CITY OF ALBUQUERQUE

August 28, 2018

**RE: St Joseph on the Rio Grande Church
5901 St Joseph Dr NW
Grading and Drainage Plan
Engineer's Stamp Date: 8/21/18
Hydrology File: G11D014A**

Based on the submittal received on 8/22/18, the Grading and Drainage Plan cannot be approved for Building Permit until the following are corrected:

PROPOSED BASIN MAP

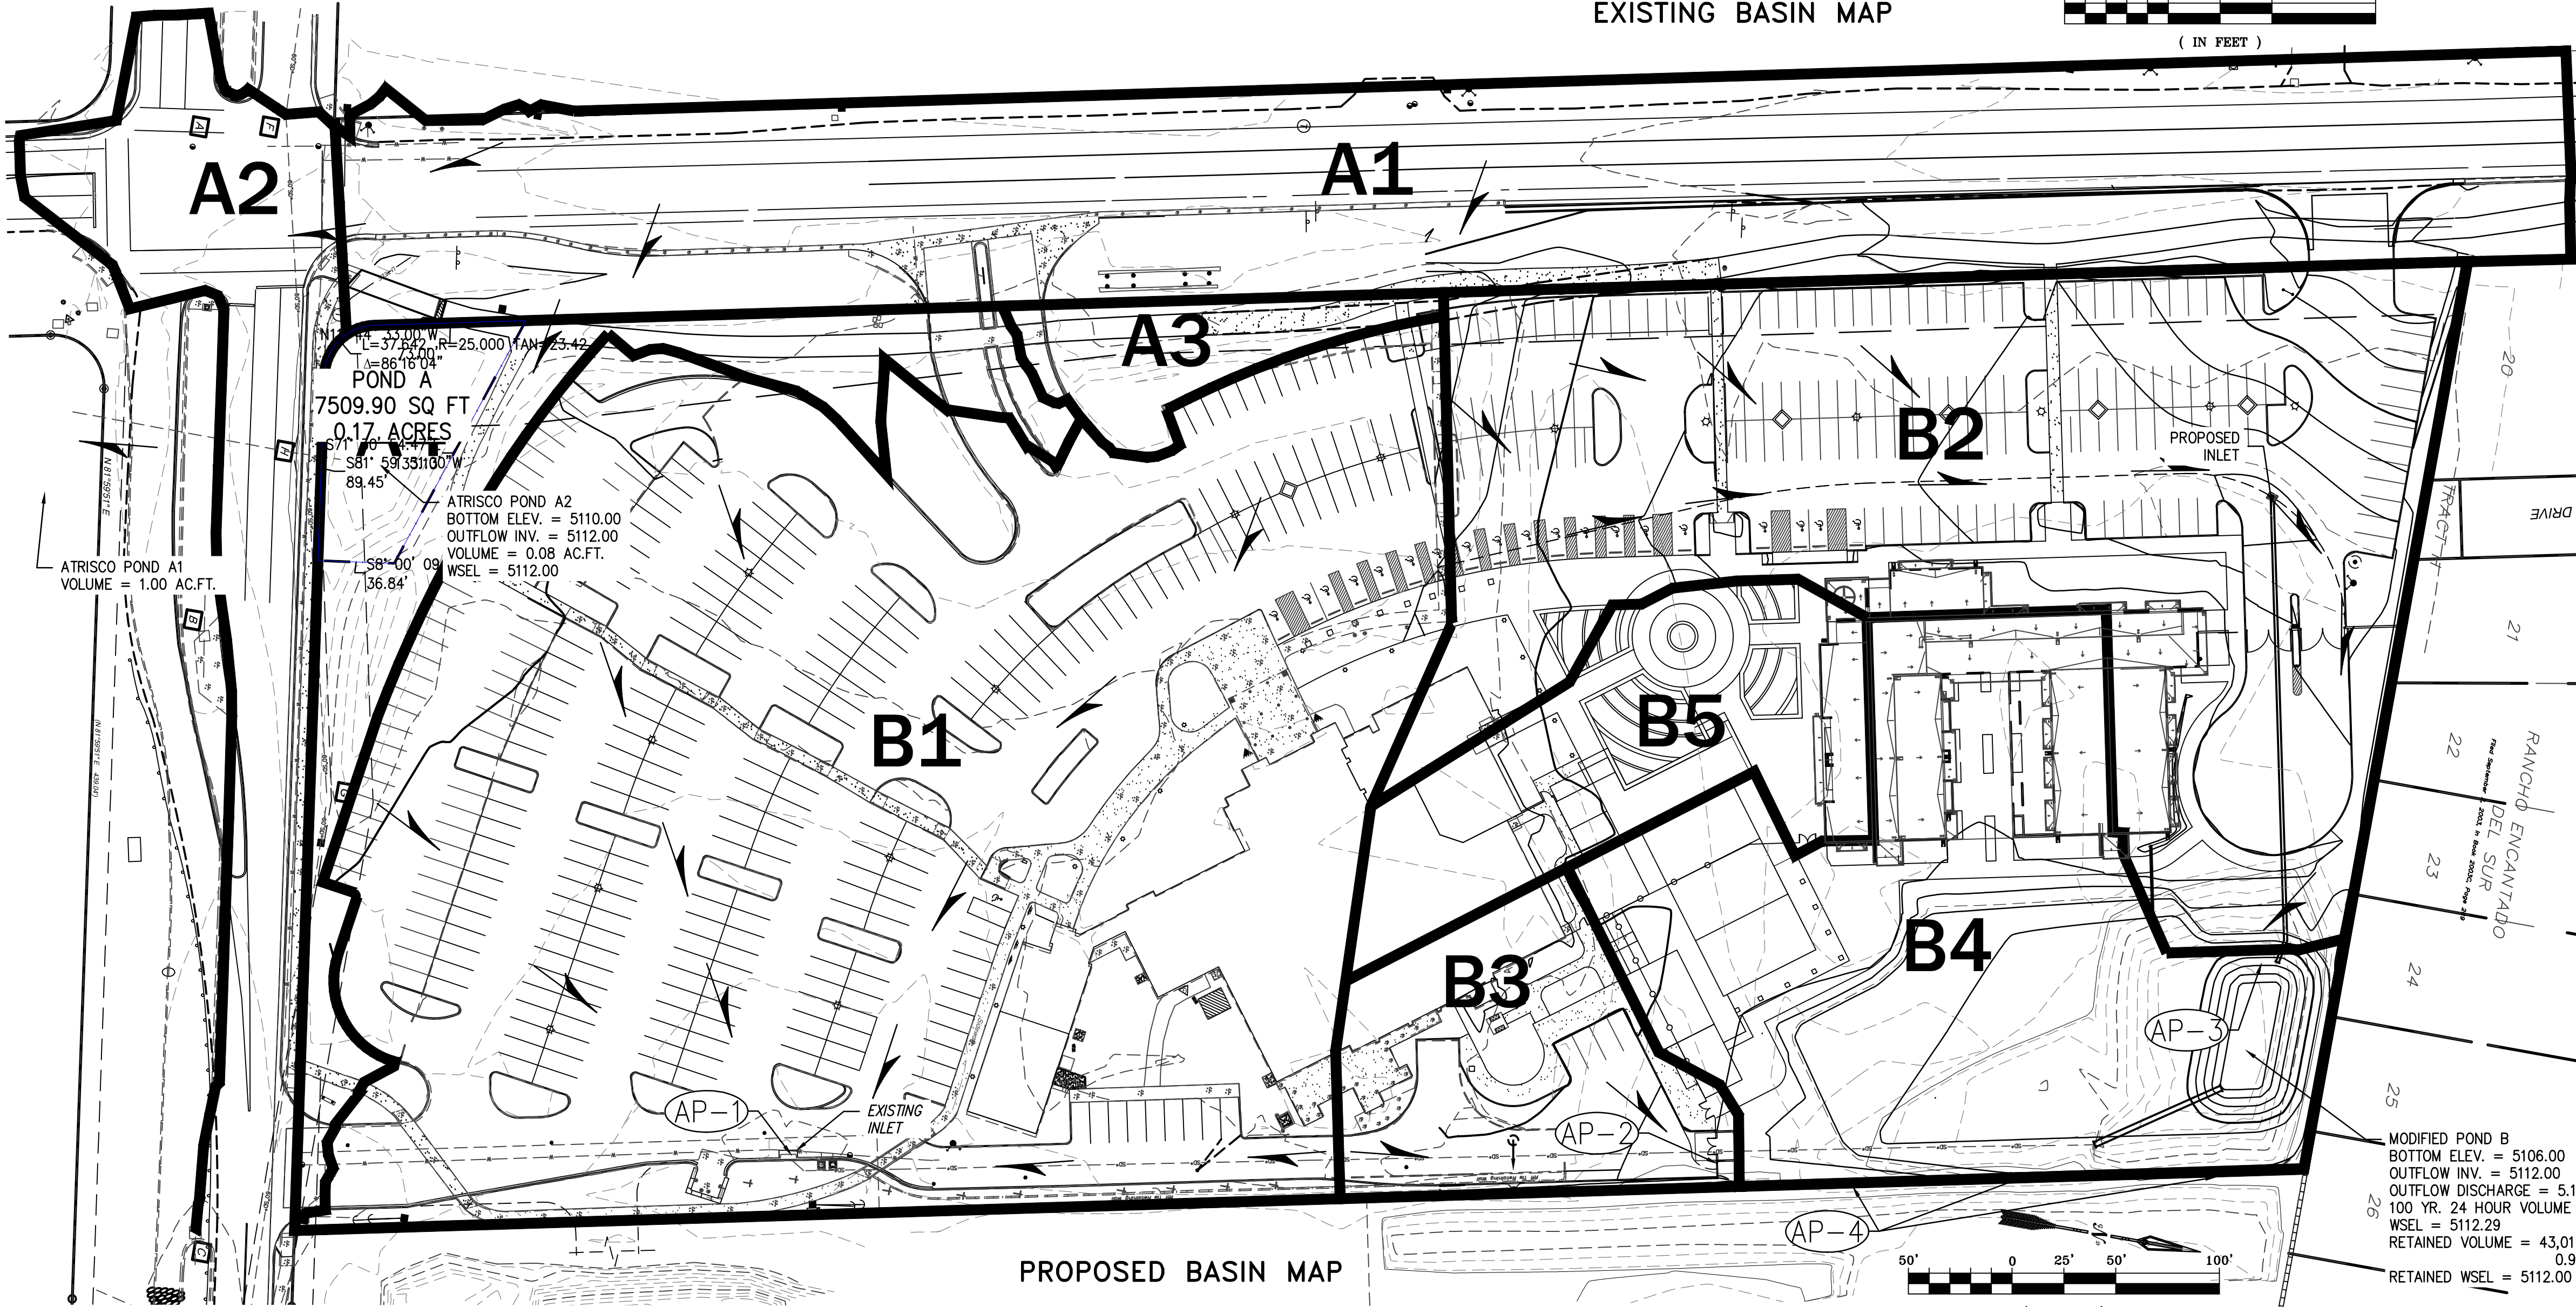
3. All drainage structures (pipes, inlets spillways, ponds, outfalls, etc...) need to be sized and detailed in a drainage report including:
 - a. Delineation of on-site and off-site contributing watersheds and/or drainage basins is required and needs to be included in this drainage report.

- b. Hydrology Calculations per DPM 22.2. The accuracy of the AHYMO model cannot be evaluated without the supporting drainage basin map.
 - c. Hydraulic Calculations per DPM 22.3 documenting:

1 POND B SECTION
Scale: 1:40

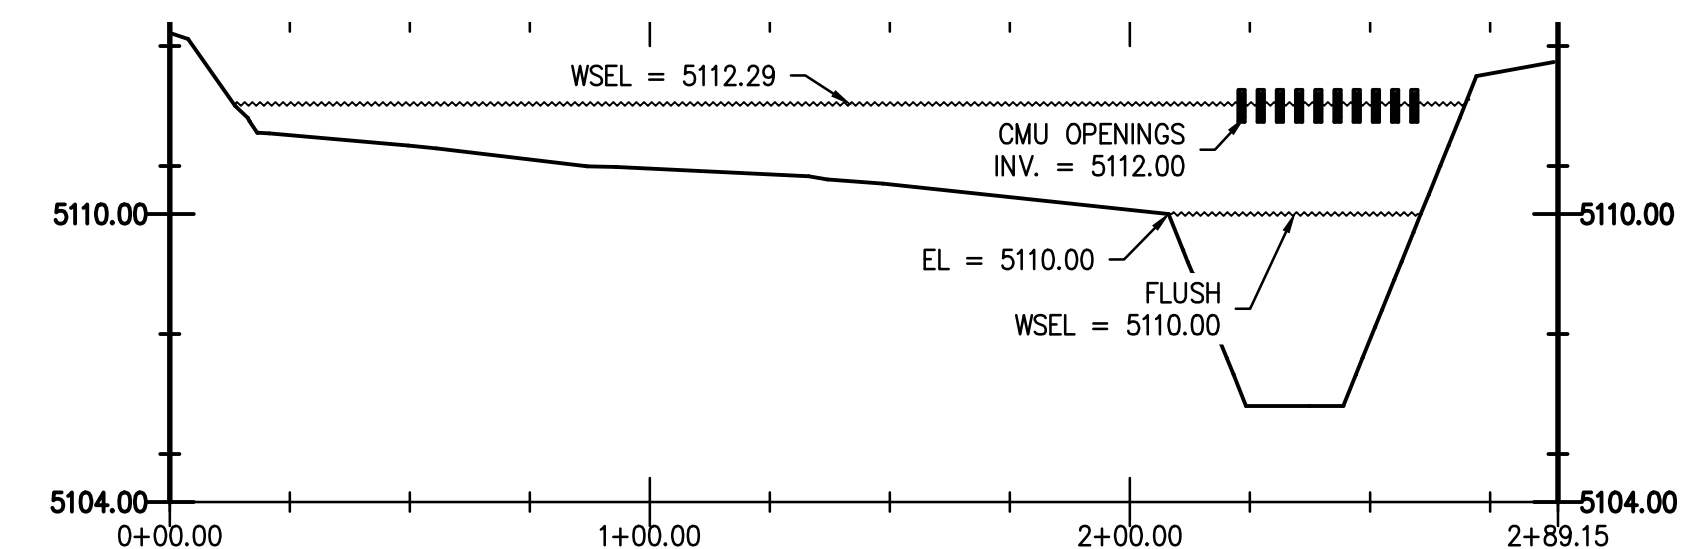
- iii. Details of each pond including typical sections, dimensions, and spot elevations. Typical sections are missing.
- iv. Pond routing calculations with hydraulic modeling and rating curves must be provided. No credit is given for infiltration into the pond bottom; this needs to be removed from the storage/discharge table and pond routing calculations.
- v. Both the first flush WSE and the 100-yr WSE must be shown; include the ponding areas in the parking lots.
- vi. Details of all pond outfall structures, including typical sections, dimensions, and spot elevations. No information has been provided for the turned-block outfall for pond B. This will need to be designed to accommodate the 100-yr peak inflow.
